Consultation Response from KC, Conservation and Design		
2021/93306 61-65, New Street, Huddersfield, HD1 2BQ		
Listed Building Consent for conversion of existing buildings, erection of split-level seven storey extension comprising four-storey stairwell, five-storey roof-top tower block and enclosed courtyard to form 31 dwellings and sub-division of the retail unit forming 61-63 New Street (within a Conservation Area)		
Date Responded: 27.6.22	Responding Officer: Sue Brooks	Responding Ref:
<p>61-65 New Street is part of a terrace of retail premises located within the Huddersfield Town Centre Conservation Area. The facades face New Street which is one of the principal shopping streets within the town centre and the north facing side elevation faces Albert Yard. 61 New Street is a three-storey Grade II listed mid-terraced building which dates to the early 19th century. This property has a white lime rendered façade and stone slate roof, with a modern shop front on the ground floor, two pairs of tripartite windows on the first floor and two sash windows on the second floor.</p> <p>63 New Street is described within the same list description, and the building projecting to the east from

PROPOSED ELEVATIONS SHEET 1

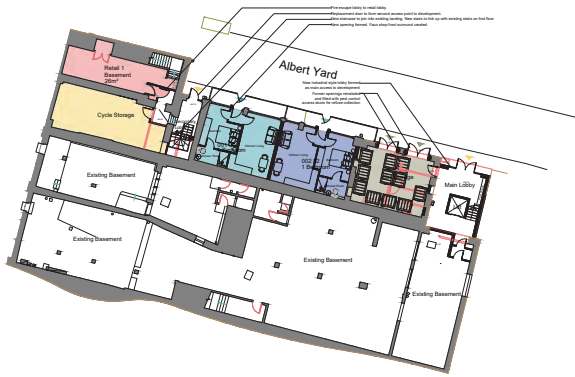
The most prominent elevation of this building is the north elevation facing Albert Yard. This elevation is constructed in coursed hammer dressed stone with ranges of large timber framed windows on the upper floors, mostly sashes, fixed lights and casements with some leaded light glazing. Some windows appear to be original. At the west end of this elevation are loading doors on the upper floors which are indicative of the historic function, and on the ground-floor are later shop fronts, some blocked up and some with security shutters. A large section at the east end has been rebuilt and finished in painted render.

This building is typical of the 19th century warehouse buildings within Huddersfield and despite the later alterations which make a negative impact, including the render and external fire escape, the building itself makes a positive contribution to the character of the conservation area. It could be enhanced by the reinstatement of traditional windows throughout, with natural stonework or a well-designed contrasting finish in the rendered areas, and well-designed treatment to the east elevation which is visible from the eastern end of the yard.

The application states that the existing windows will be repaired or replaced to match the existing, with secondary glazing installed. In some cases, later windows with no historic interest have been inserted and we would recommend that these are replaced to reflect the design of the earlier windows.

The removal of metal window bars is proposed. If their removal causes damage to the stonework, this should be repaired with lime mortar to match the existing (cleaned) stonework, or with stone indent repairs to match the existing stone.

Where the external walls are rendered, the proposal is to remove this to expose the stonework. We would recommend that investigations are carried out to ensure that the substrate is coursed stonework and not a later infill. If not, alternative wall treatments should be submitted for approval.

A full height stair tower extension is proposed on the east elevation to provide upper floor access. Following revisions to the proposal, this is set back from the north elevation by one bay, with roller shutter doors at ground floor level to provide access to the retail units, and a small yard with metal gates. The removal of the fire escape and construction of a simple extension will enhance the character of the conservation area and warehouse by removing clutter from this area. However, the proposal for mid-20th century Crittal type windows and extensive areas of render on the extension, along with Crittal windows in the ground floor recessed openings of the warehouse, is unclear in this context.

We have no objections to an extension, although we would suggest that more consideration is given to the design and materials of the extension, gates and openings. If the application is supported, external material samples should be submitted for approval.

- Full window and external door details for both the warehouse and new block, including sections and elevations showing configuration, opening lights, reveals, etc.
- All stone must be natural stone, samples to be submitted along with details of coursing and edge details.
- Render colour and texture.
- Stair tower window details.
- External material samples should be submitted to demonstrate that high quality and robust materials and cladding will be used.
- Architectural details should be submitted, including junction of roof and wall, window reveals, etc.

IR PLAN

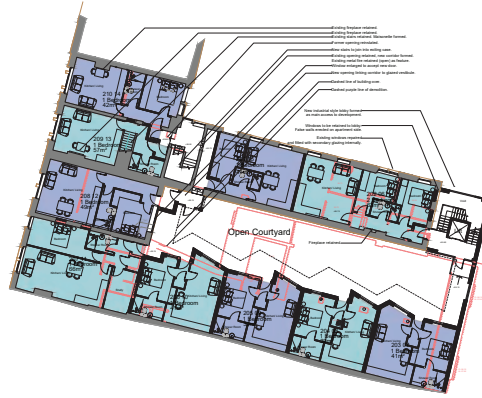
Basement (ground floor of warehouse) – A single apartment is proposed, along with internal bin storage and a meter room for the apartments. A cycle store is proposed in the basement of the retail unit facing New Street and this is accessed via a set of internal steps. The Conservation and Design Team has concerns about the proposal to provide fully glazed residential accommodation at street level where anti-social behaviour may be a problem for the residents, with cycle storage accessed via steps. We would suggest that the street level space is more suited to cycle storage rather than residential accommodation, with the railings omitted from the proposal and the front basement used to serve the retail premises above. On the Albert Yard elevation the external shop front detailing should be amended accordingly.

SECOND FLOOR PLAN

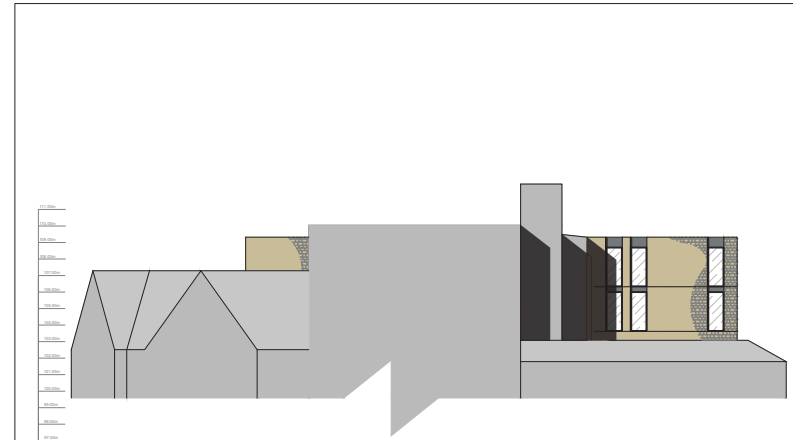
Second floor (third floor of warehouse) – The top floor of the warehouse retains some interesting historic features and detailing. The proposal is to subdivide this floor into two apartments, with the historic trusses remaining exposed, with a large, shared space area at the west end where the historic winding gear will be restored and retained. Although subdivision on the top floor will reduce the legibility of the space, it has been vacant for some time. The public benefits of bringing it back into use, while retaining historic features, outweighs the slight harm to the significance of the building.

Note: Where new finishes and partitions are proposed, no detail has been submitted to show how the historic internal details such as timber trusses, winding gear and fireplaces will be incorporated into the

proposal. If the application is supported, details need to be submitted and justified, with evidence that historic features of significance will be retained and incorporated into the proposal, and modern interventions such as surface finishes will not harm the significance or performance of the building.

ELEVATION 5 - (PARTIAL) RAMSDEN STREET

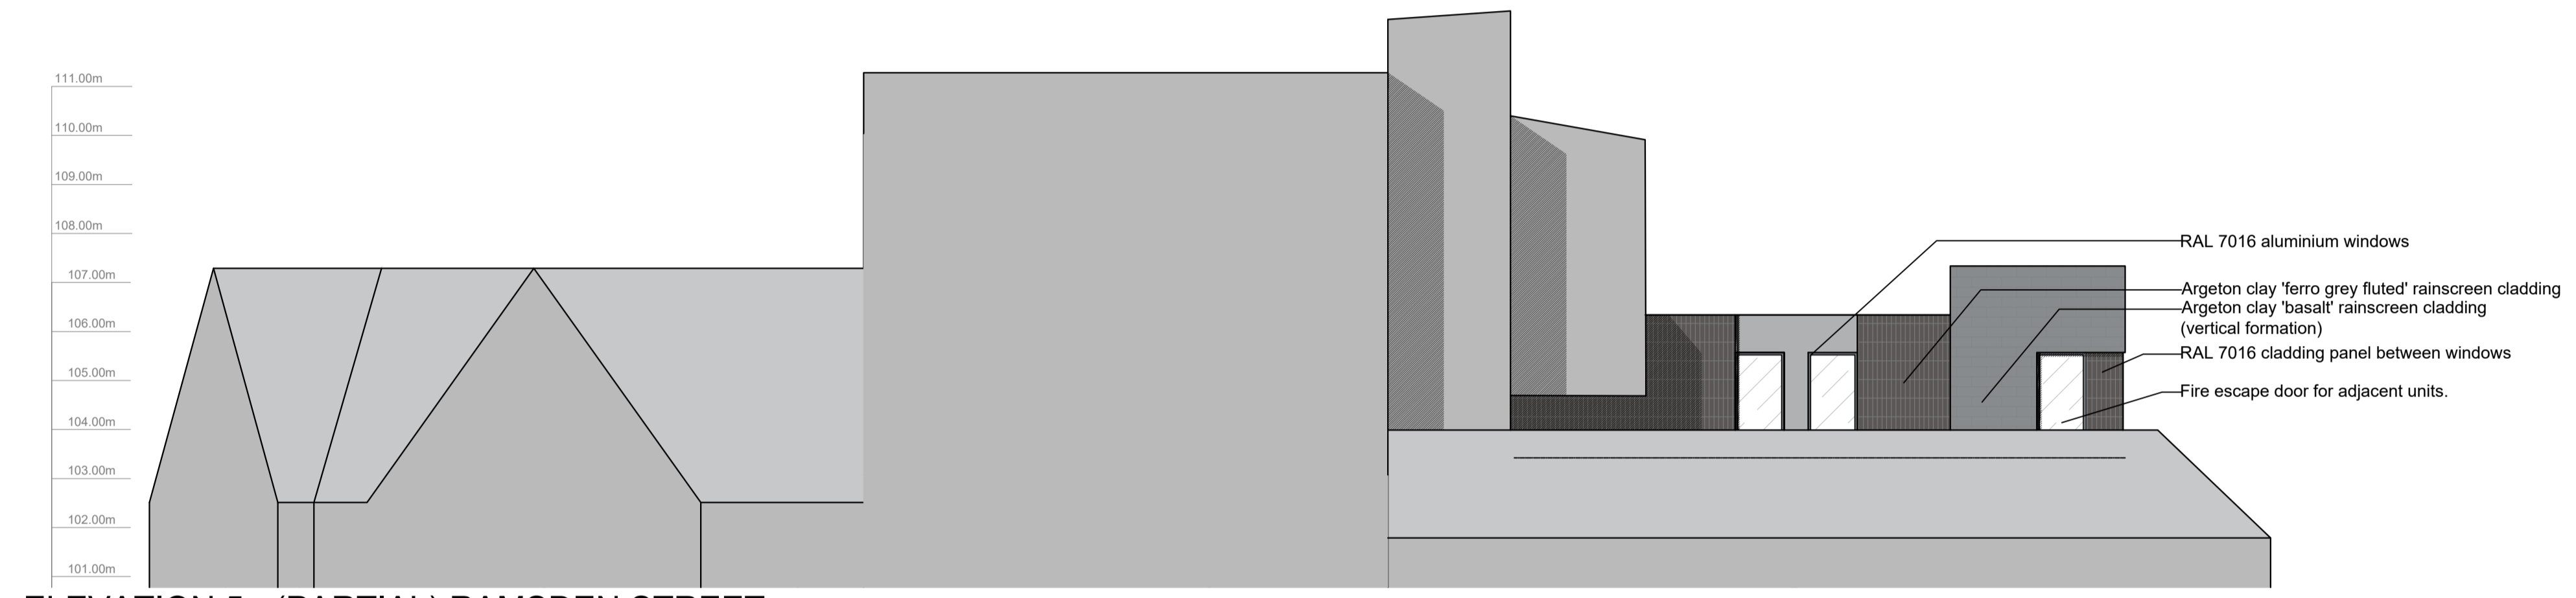
The proposed apartment block is a large flat roofed structure which extends above the predominant roofline within the immediate vicinity, particularly when viewed from the piazza to the south-east and north-east. The building is orientated from east to west, with the principal elevation facing north. This elevation is articulated with angled facades and stone cladding with a vertical emphasis, interspersed with large windows and dark grey aluminium cladding panels.

The east and west elevations are blank stone walls with little articulation. Although the visibility of the west elevation will be limited by the existing structures on New Street, the east elevation will be highly visible. This aspect is lacking in interest and rather overbearing when viewed from the Piazza. Although precedents for tall buildings have been set in this area in the past, with the late 20th century tower blocks at 6 Ramsden Street and Ramsden House nearby, both make a negative contribution to the character of the conservation area and the setting of the nearby listed buildings. The construction of another seven-storey block would cause further harm to this setting and character.

Policy LP24 requires the form, scale, layout and details of all development to respect and enhance the character of the townscape. We accept that the visibility of the building will be limited from New Street and Albert Yard as the existing buildings will screen it to a large extent from these aspects. However, it will be highly visible from the south-east and north-east, particularly in context with Huddersfield Library and from the piazza and where the cultural heart regeneration scheme is proposed. We feel that a building of this scale will dominate the townscape from this aspect.

The preferred scenario would be the restoration and reuse of the former warehouse, whether this is for commercial, retail or residential space, without the construction of the new building. If some development can be justified, we would suggest that it is scaled back and reduced in size to reflect the predominant roofline, with consideration given to how the design will sit in context with the library and piazza, as well as the proposed landscaping of the Cultural Heart. We would suggest that, following amendments, 3D visuals are produced which show the building from Princess Alexandra Walk to the south-east, to assess any harm from this aspect.
